**Consultation Response from KC,
Lead Local Flood Authority**

2024/92365 Land off, Blackmoorfoot Road and Felks Street, Crosland Moor, Huddersfield, HD4 7AD

Date Responded: 4/10/2024

Title: **External Levels - Sheet 4**

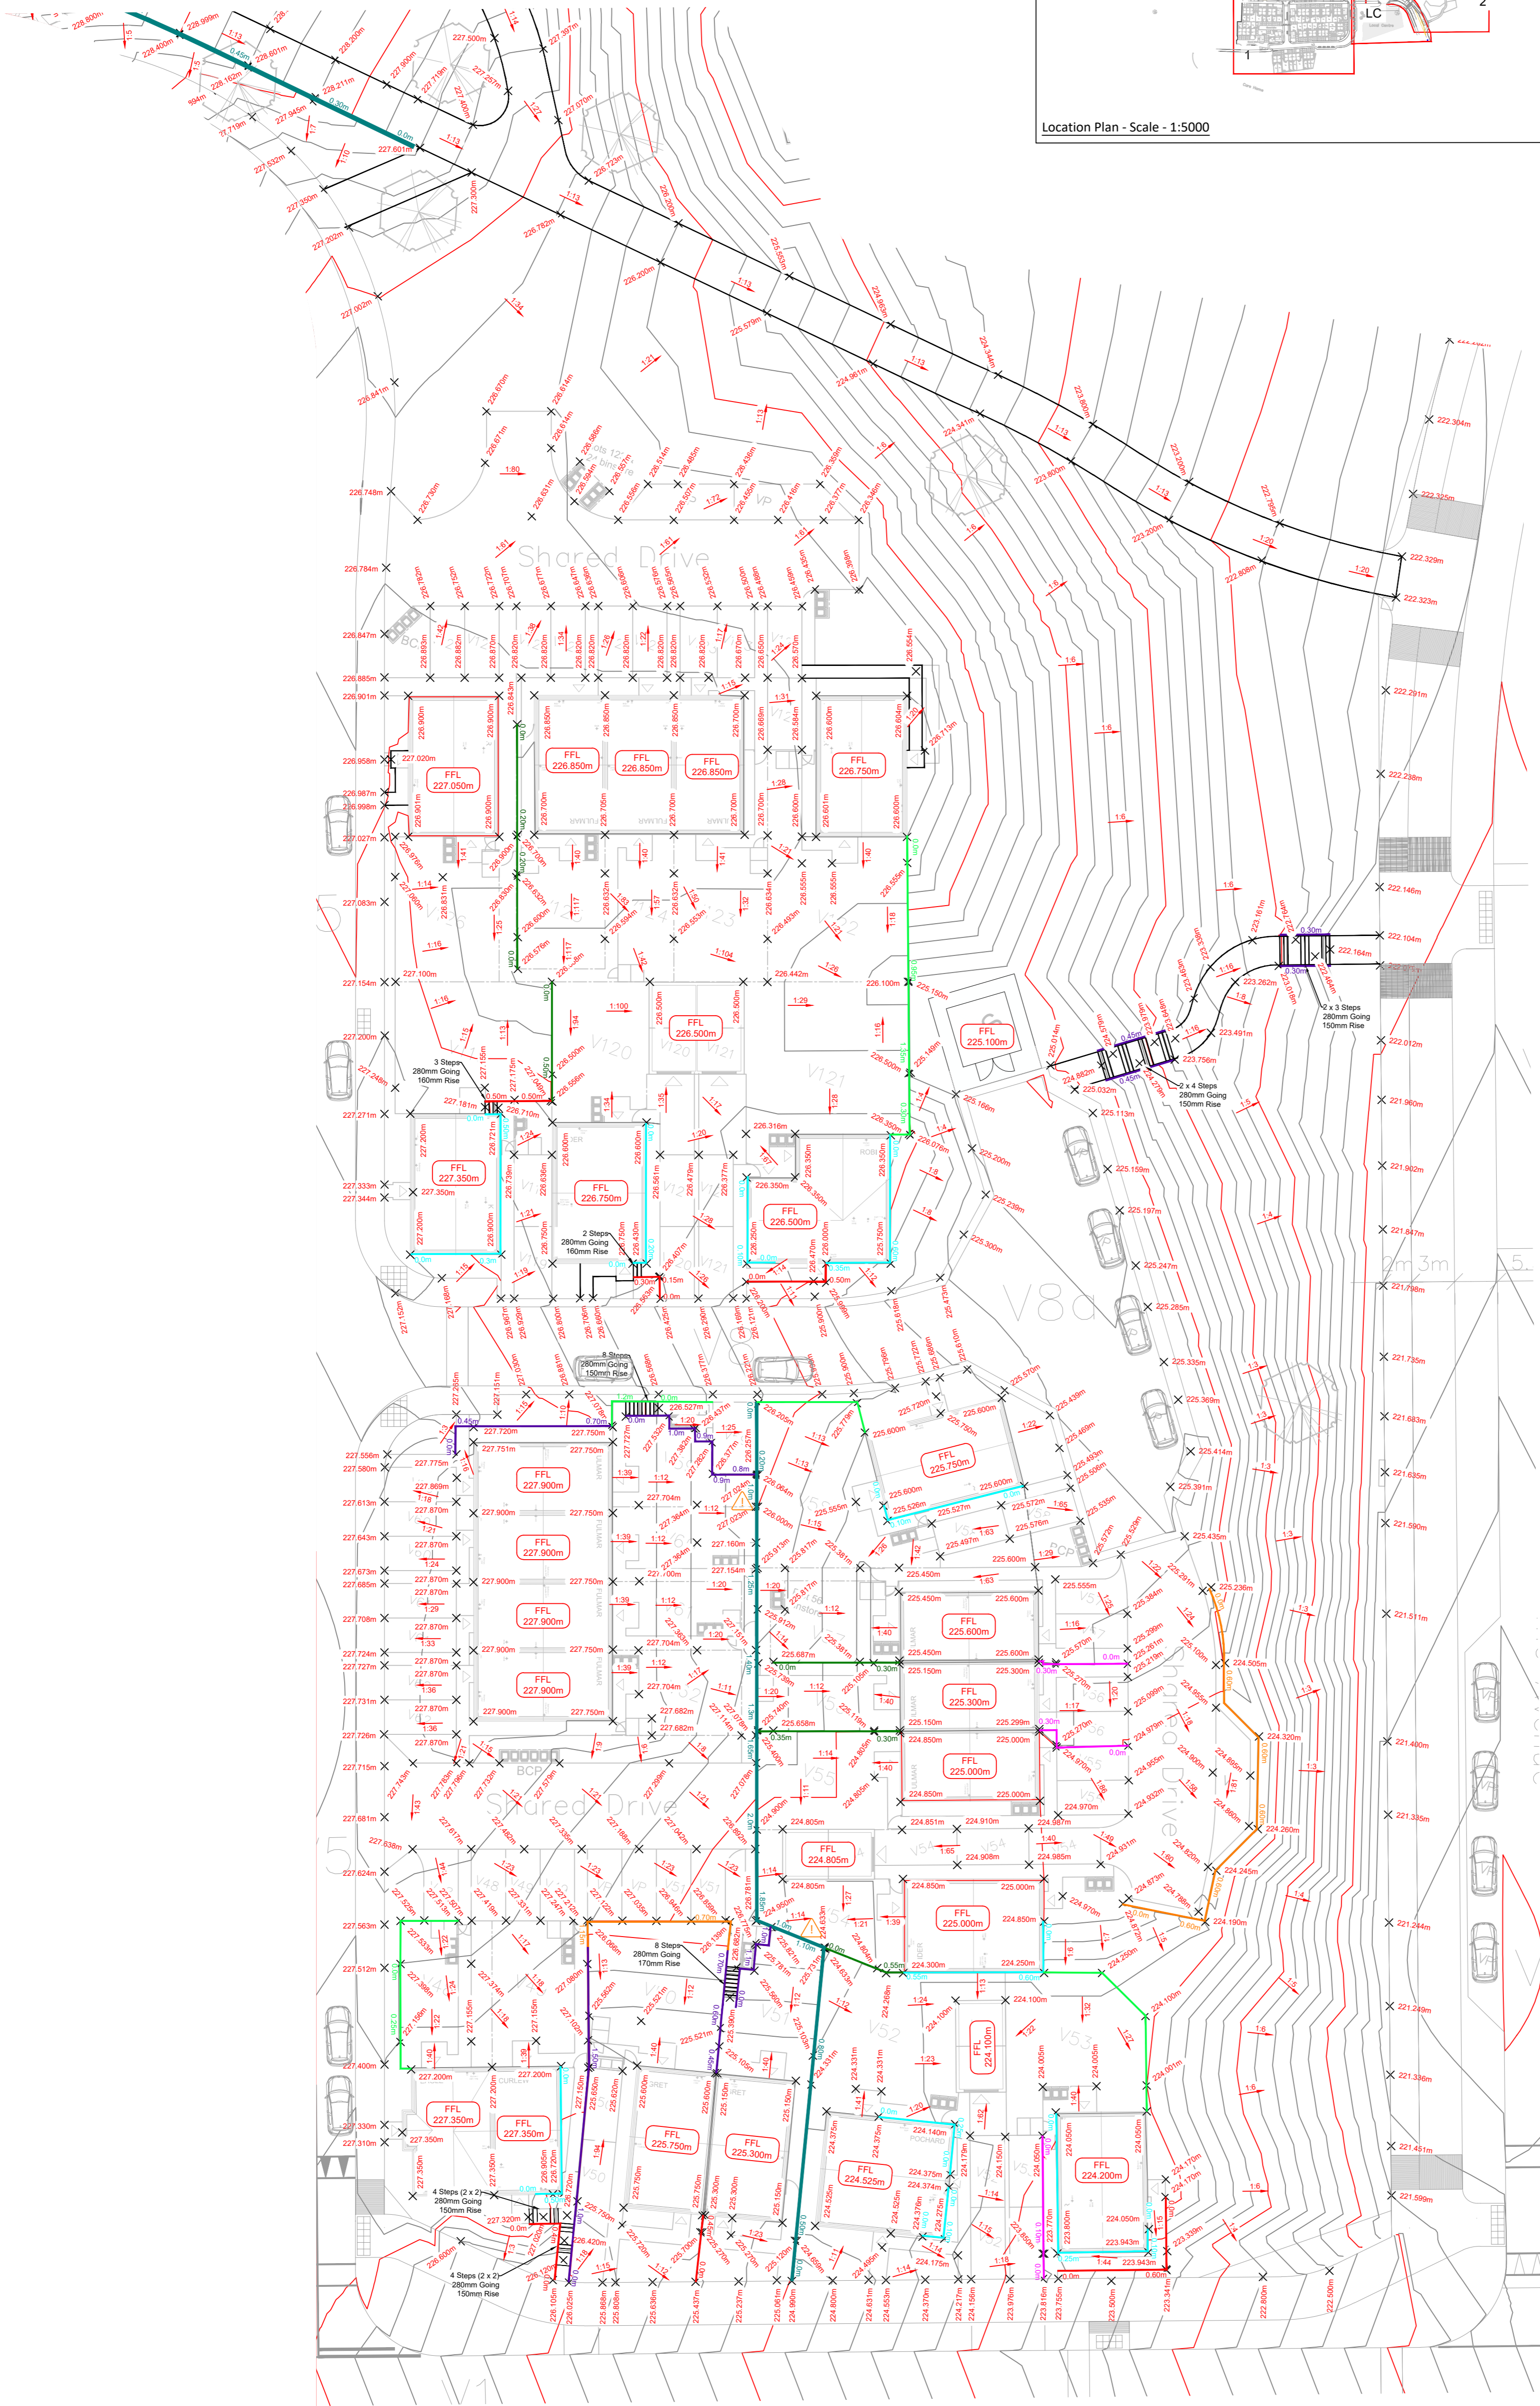
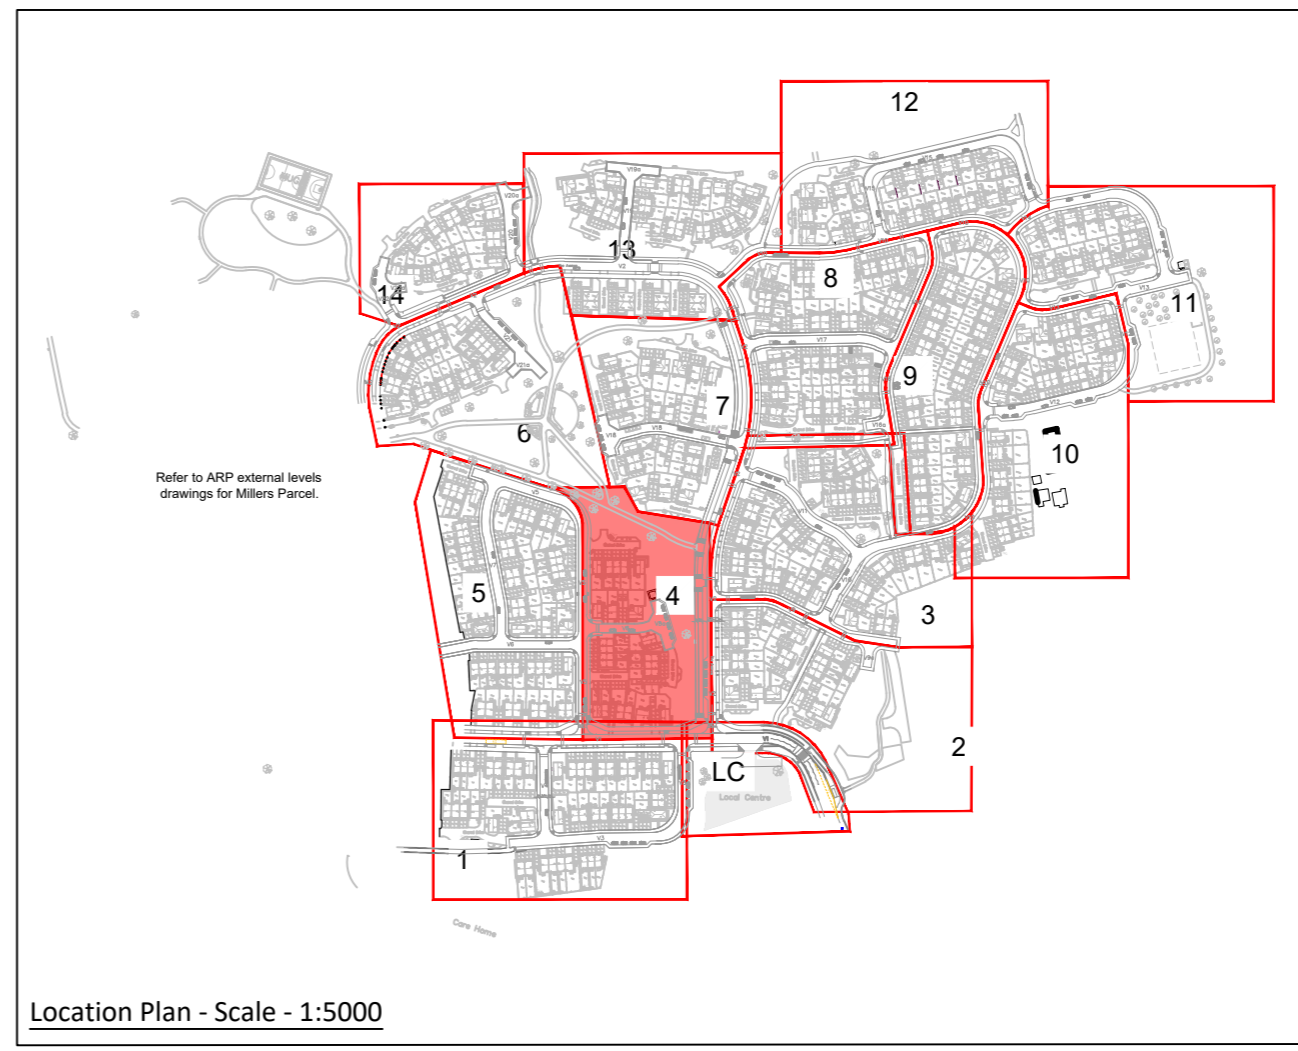
After examining the submissions relating to flood routing, the design fails to utilise roads and open space as conduits throughout the site. The results in flood routing through curtilages in several places. This goes against first principles.

There are places where additional information with levels on private shared driveways and fall shown away from property may result in some concerns removed.

- Plots 215-225/6
- Plot 381
- Plot 422-423
- Plots 336/309
- Plots 445/457
- Plots 604/607
